Application No: R/111/22/HH
Site Address: 35 Hawke Close Rustington BN16 2AT
Description of works: Single storey extension to side garage including new pitched roof and installation of an air source heat pump.

Thank you for your internet representation made on 15th June 2022 which has been recorded as no objection with the comments as follows:

No 35HC - 206 Rev.

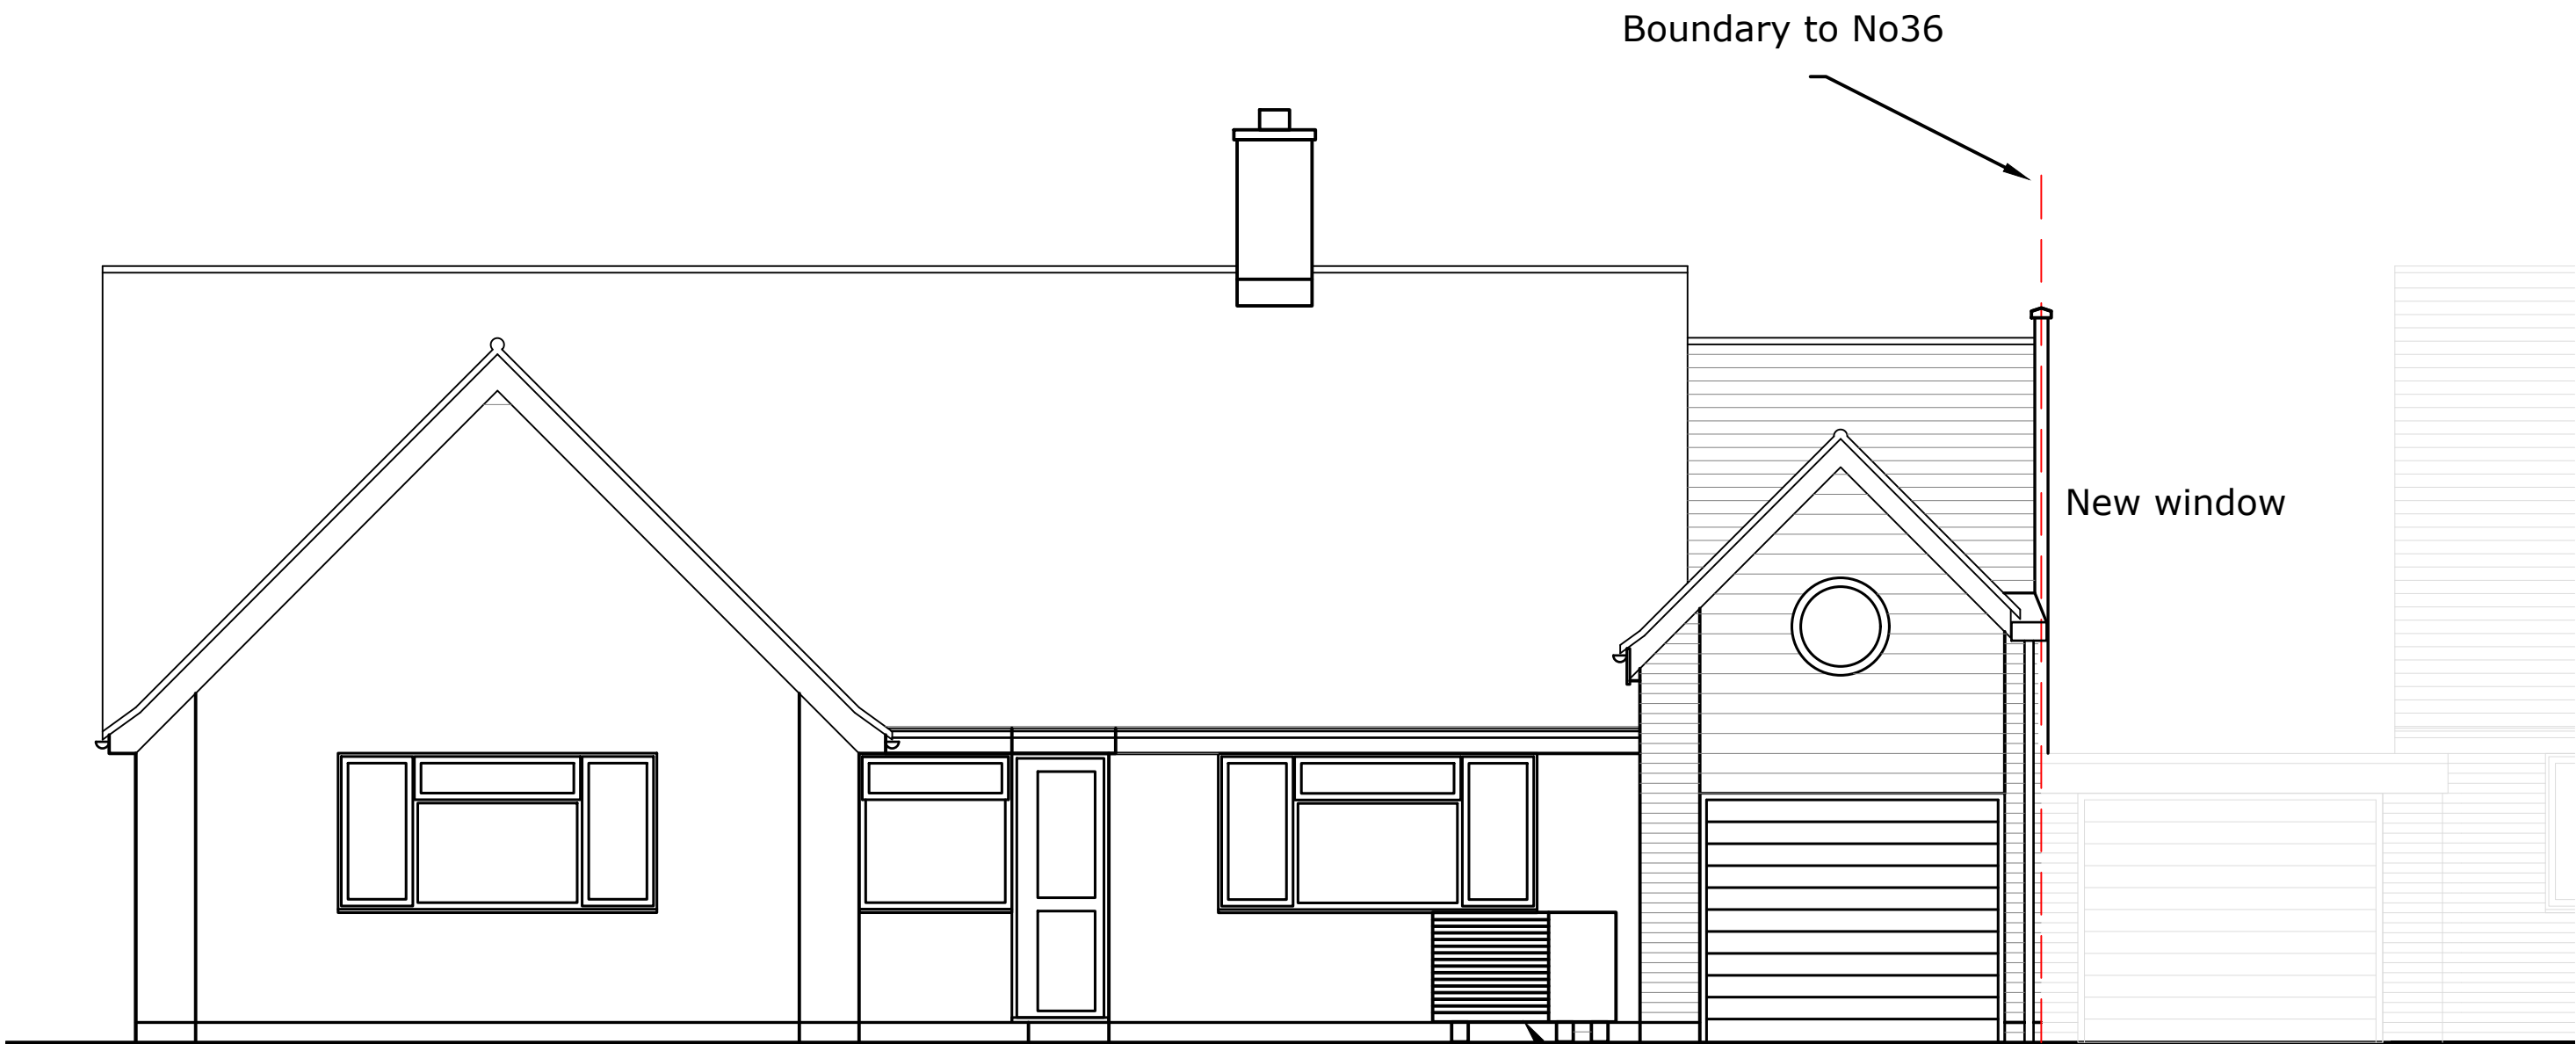
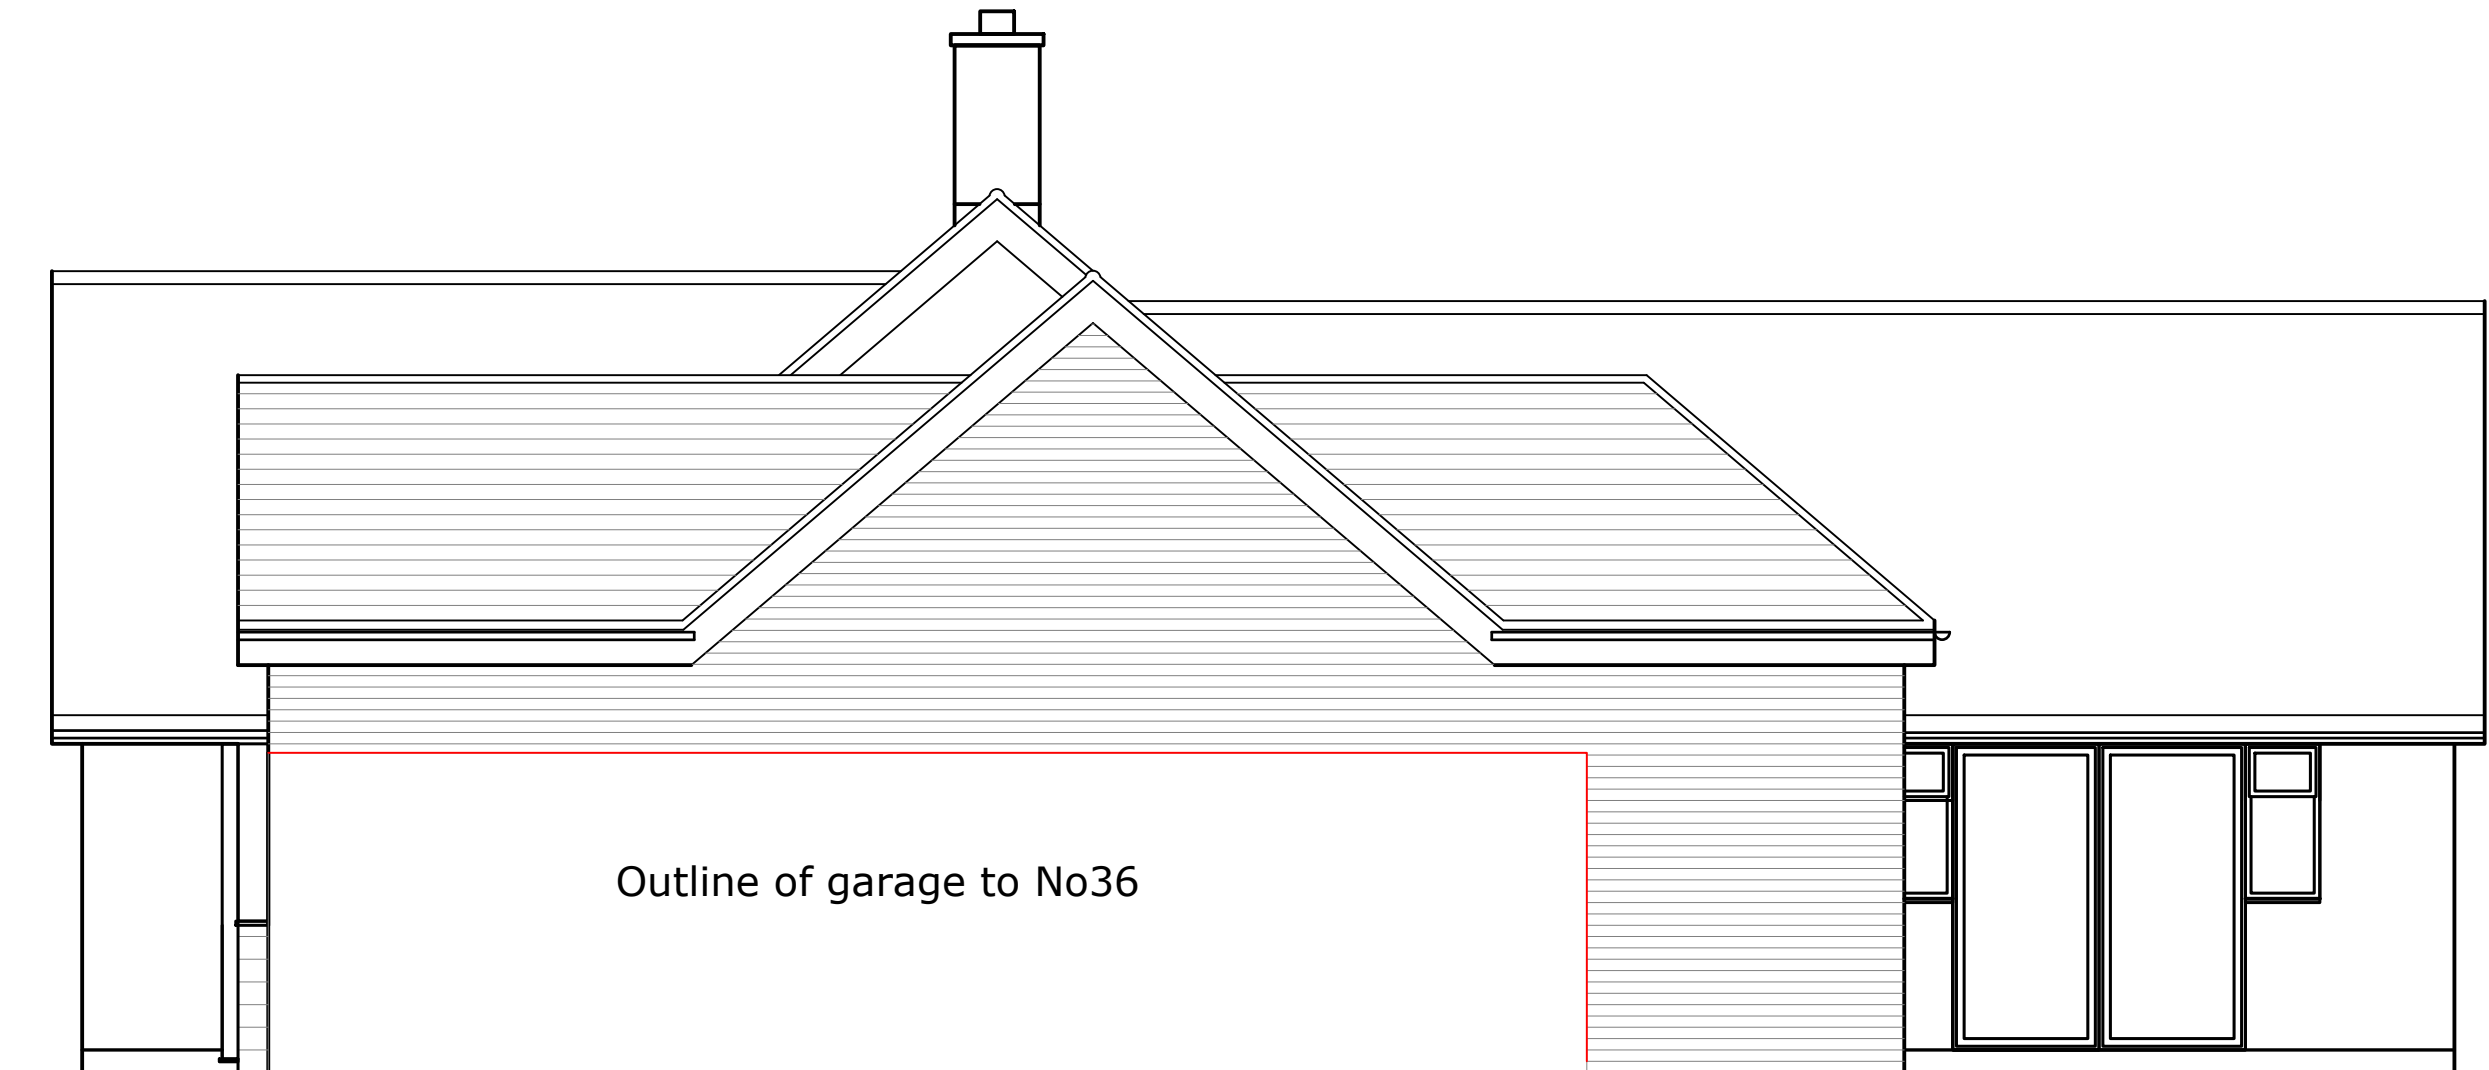
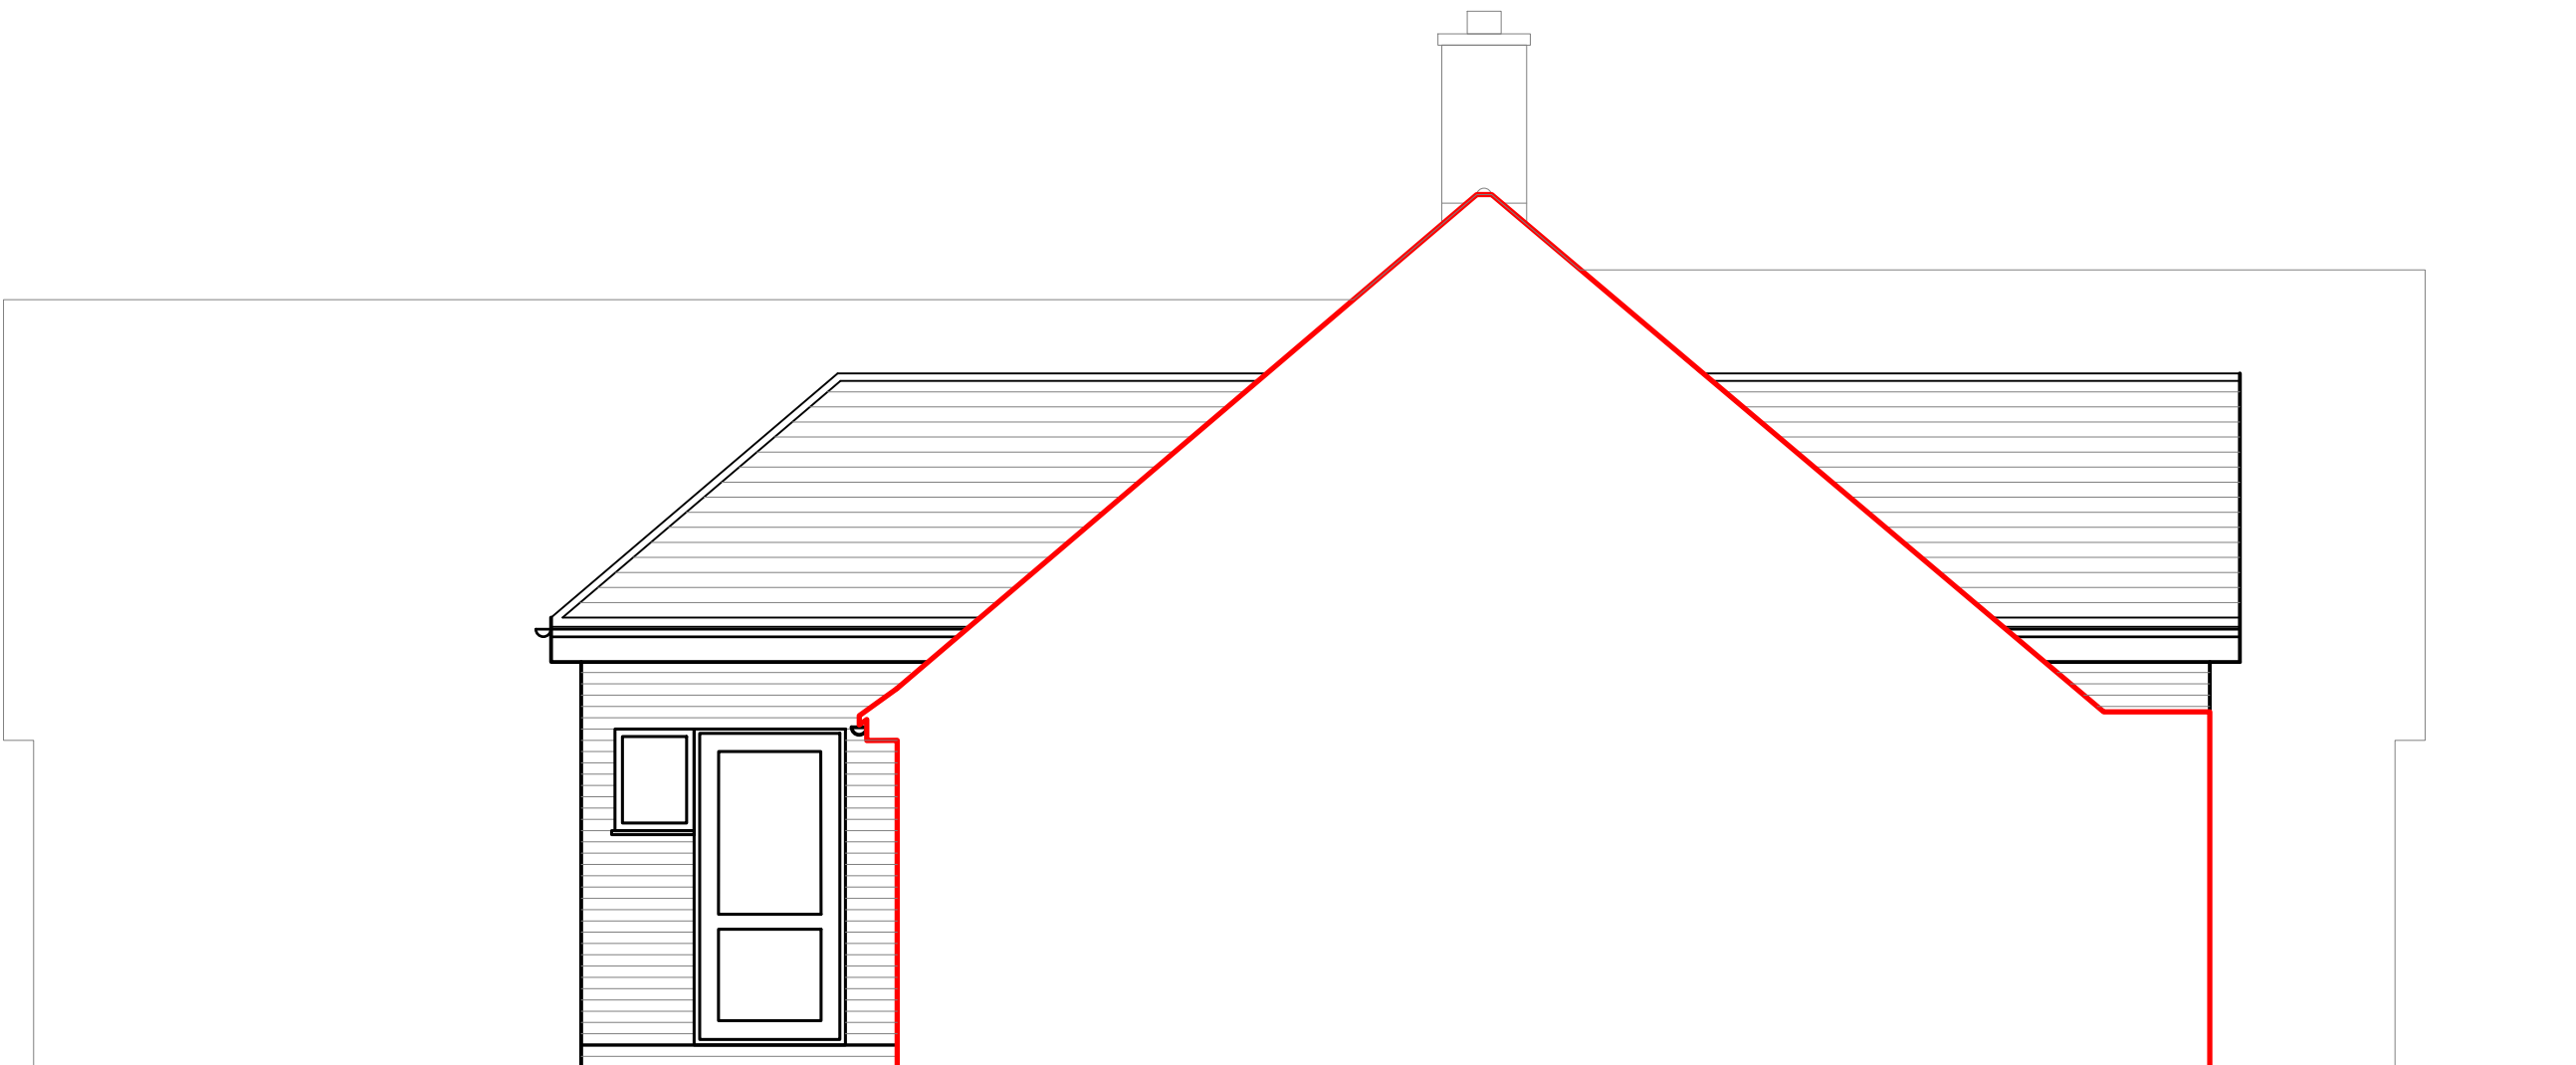
I have no objection to the "Possible siting of Air Source Heat Pump" shown on plan 35HC-206. Which shows it installed at the front right hand side of the property.

However I would have an objection due to noise if it were proposed to be situated anywhere near our boundary (east side of number 35). Especially as this is where our bedrooms and living rooms are situated.
